An
Bord
Pleanála

Inspector's Report ABP 304094-19

Whether the proposed farm building for housing of horses and storage of food is or is not development or is or is not exempted development

Knockaneroe, Kilbrittain, Co. Cork

PROJECT
Stables

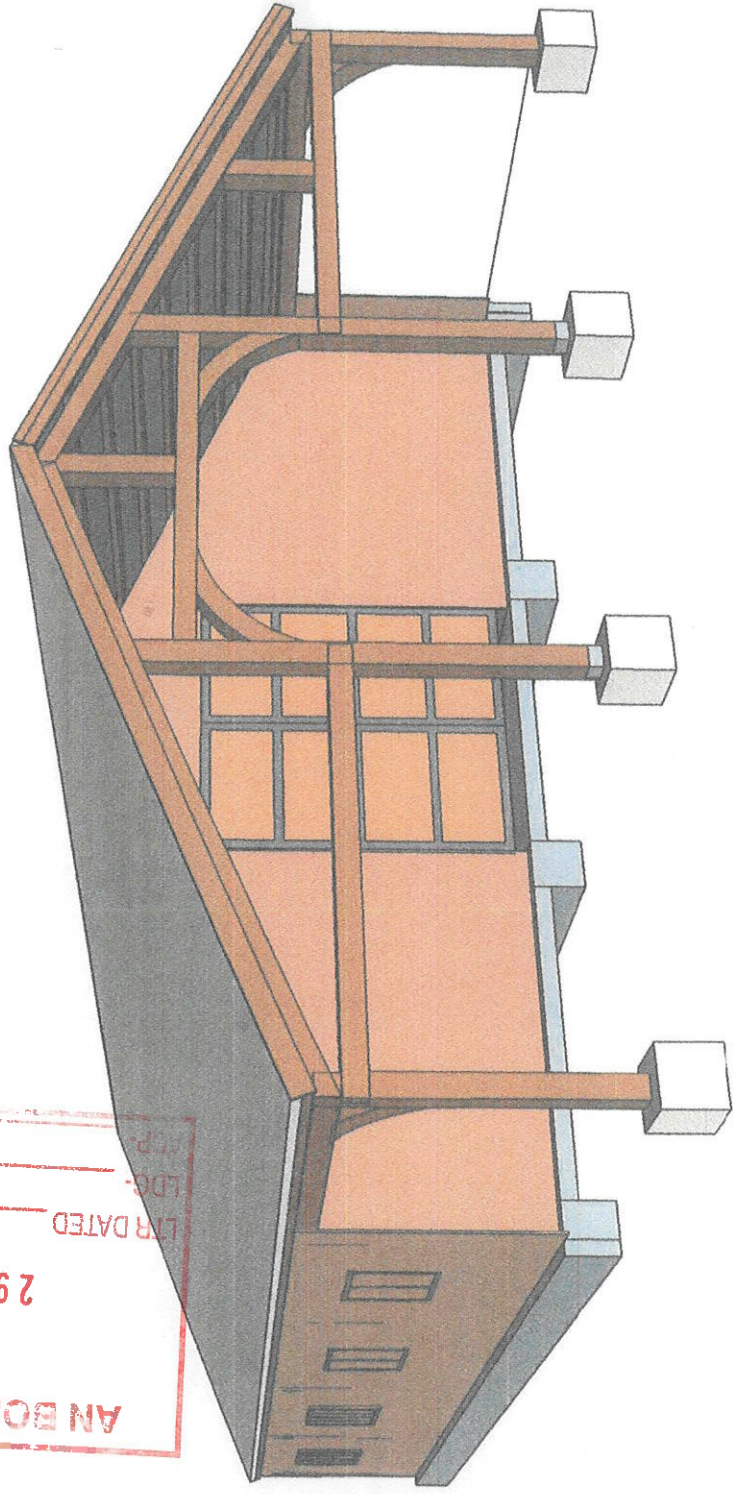
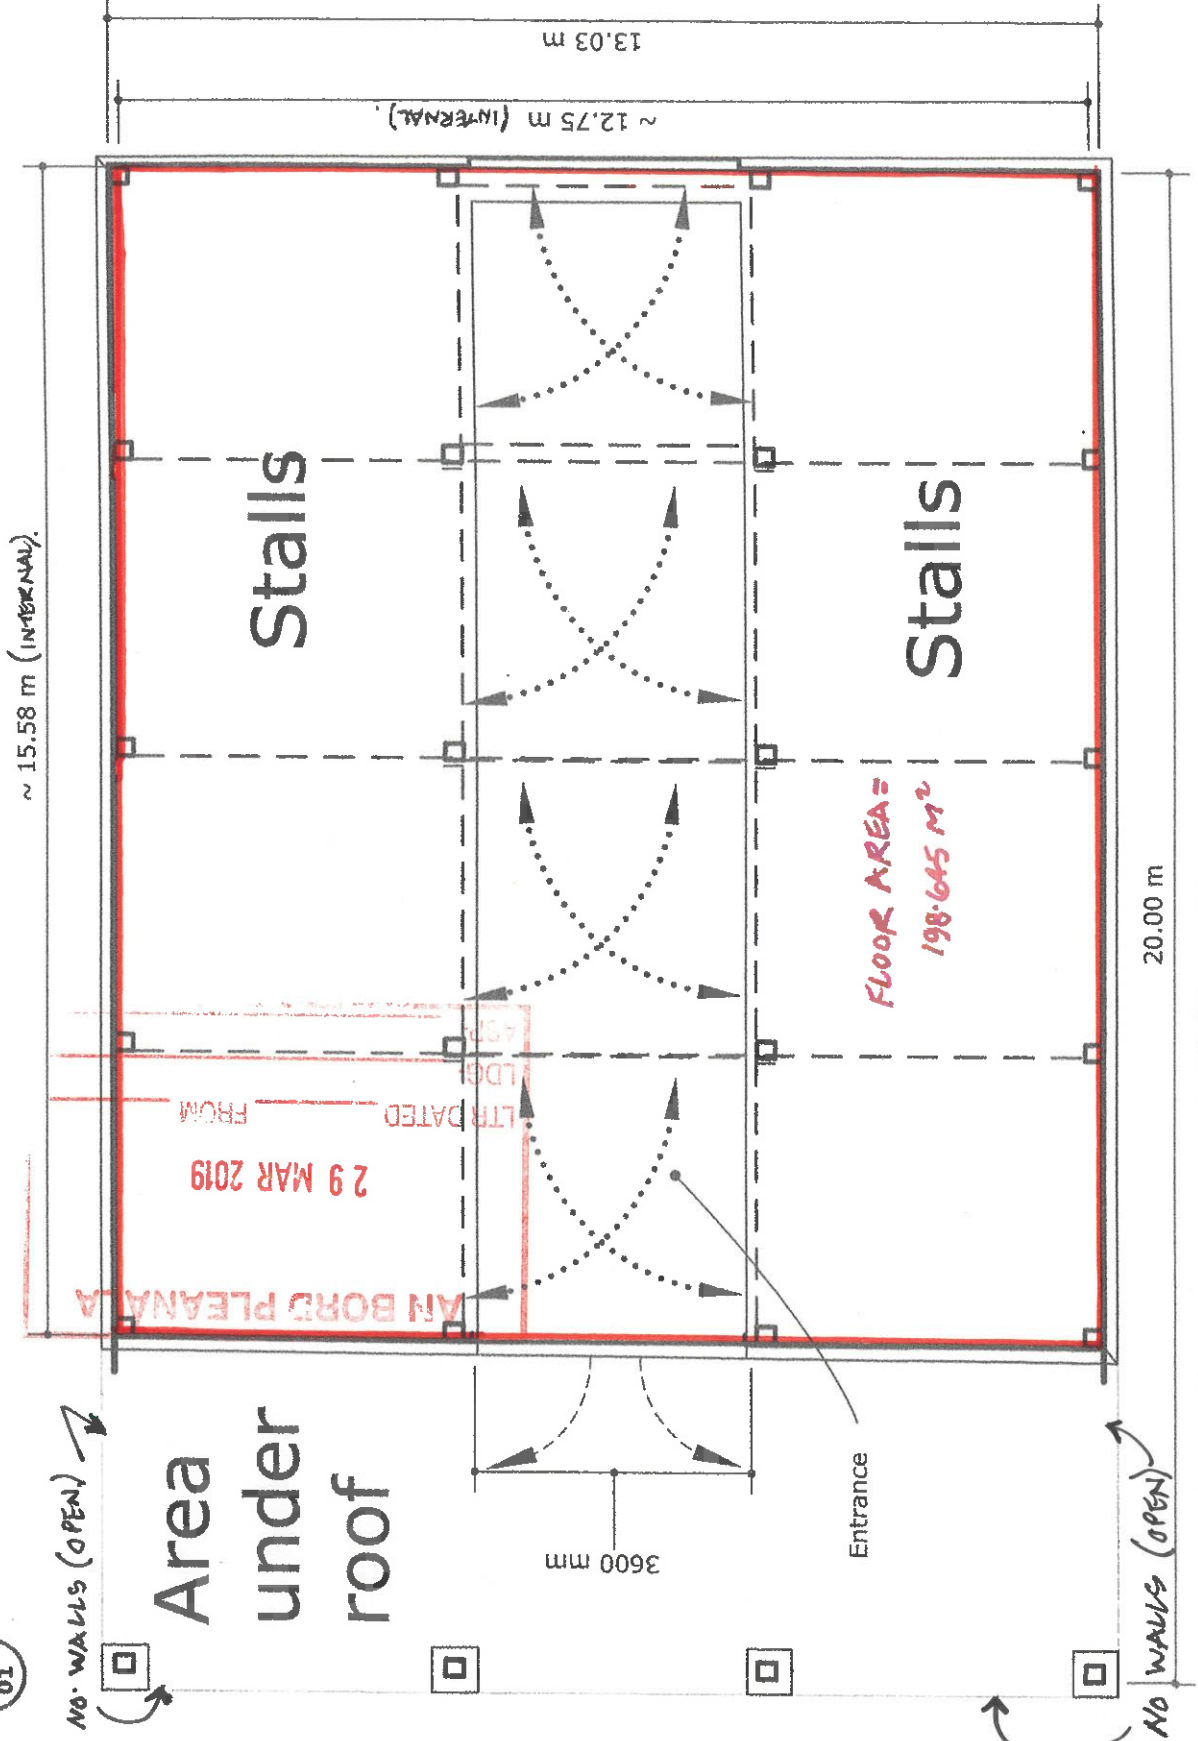
At the outset I consider that it is appropriate to clarify the nature and extent of the development which is the subject of the referral. From my interpretation of the documentation on file and an assessment of the Council Planner's reports the structure, as partly constructed on site at the time of her inspection, was deemed to be the subject of the question. As noted from the photographs attached to her 1st

report the entire concrete floor area was enclosed by concrete walls giving an approx. floor area of 252 sq.m.

On my inspection I noted that the concrete walls to the rear (southern) end of the structure had been removed with the timber columns and roof trusses covering the entire floor area remaining in place. This would correspond with the plans of the proposed structure which accompany the referral which would provide for an enclosed floor area of c.198.6 sq.m. with an open area to the south, albeit roofed.

South elevation
scale: 1:100

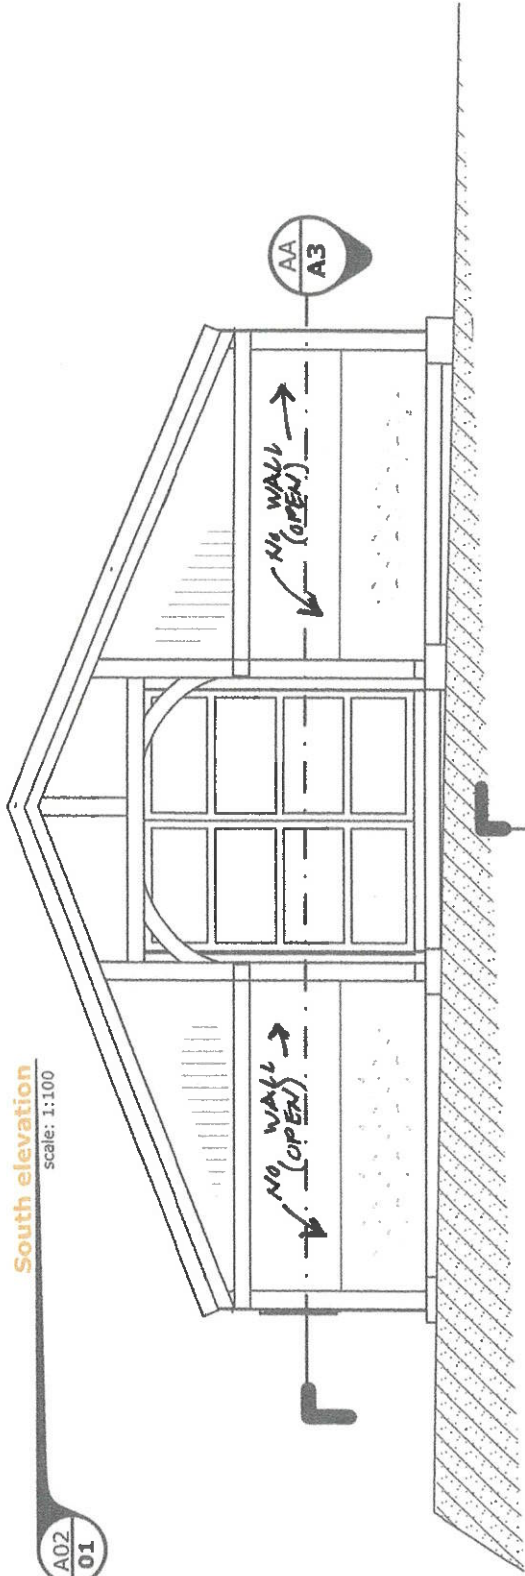
Farm building for the keeping of horses and storage of food. It would have a fully enclosed floor area of 198.6 sq.m. with a roofed open area on the southern elevation with a floor area of c. 53 sq.m. The structure is to have an overall height of 5.5 metres.

As per the plans accompanying the referral the gross floor area within the walled structure would be 198.645 sq.m. which complies with the 200 sq.m. limit. The question is whether the open, albeit roofed area, to the south elevation would be included within the gross floor area. It is proposed for the storage of feed for the horses.

On the basis of this definition I would conclude that the said area does not come within the gross floor area and, as such, the structure as proposed comes within the 200 sq.m. gross floor area parameter. The use of the roofed open area is for the storage of food for the horses and, in my view, would be considered to be ancillary to the primary purpose of the building.
